From: Chris Moore [REDACTED]
Sent: 26 July 2017 08:29
To: Simon Davis
Cc: 'Isitt, Matt, Vodafone Group'
Subject: RE: FP/127/17/PL 2 Second Avenue, Felpham,

From: Simon Davis [<mailto:Simon.Davis@arun.gov.uk>]
Sent: 18 July 2017 13:02
To: 'Chris Moore' <chris@sussexbuildingconsultancy.co.uk>
Subject: FP/127/17/PL 2 Second Avenue, Felpham,

SITE/ROOF PLAN - 1/500

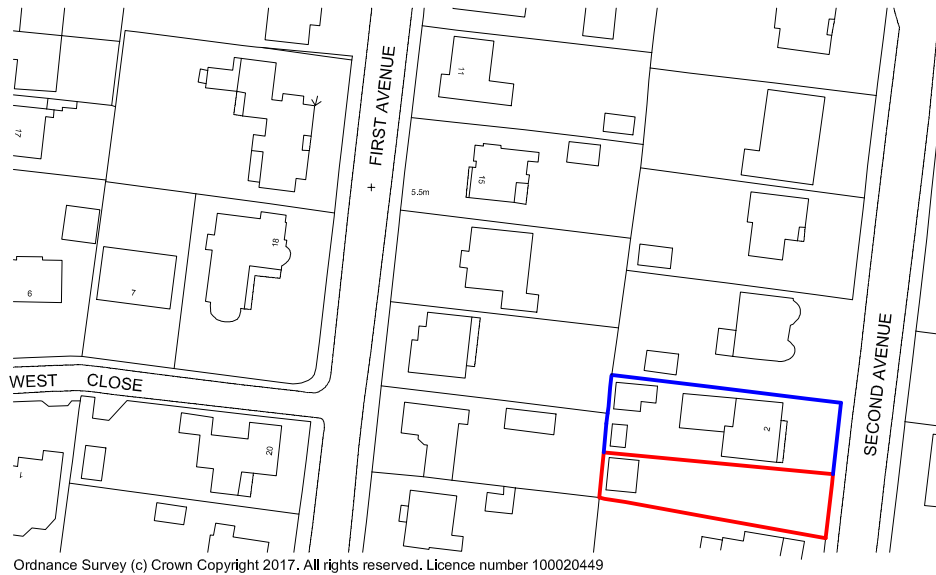
I've had an objection from a resident who states that that the adjacent house to the south, 'Shergar' has not been drawn properly in respect of garage and lounge extensions. I've looked at your plans versus my photos and it seems that the side and rear are correct but possibly there is a front extension which isn't shown. Anyway, can you check and comment please. We have had complaints before where we have decided applications based on incorrect plans of neighbouring properties.

I have double checked on site and on the 1/100 plans the building is set 100 mm further forward and as you said the front extension was not shown on the downloaded Ordinance Survey detail – amended detail attached.
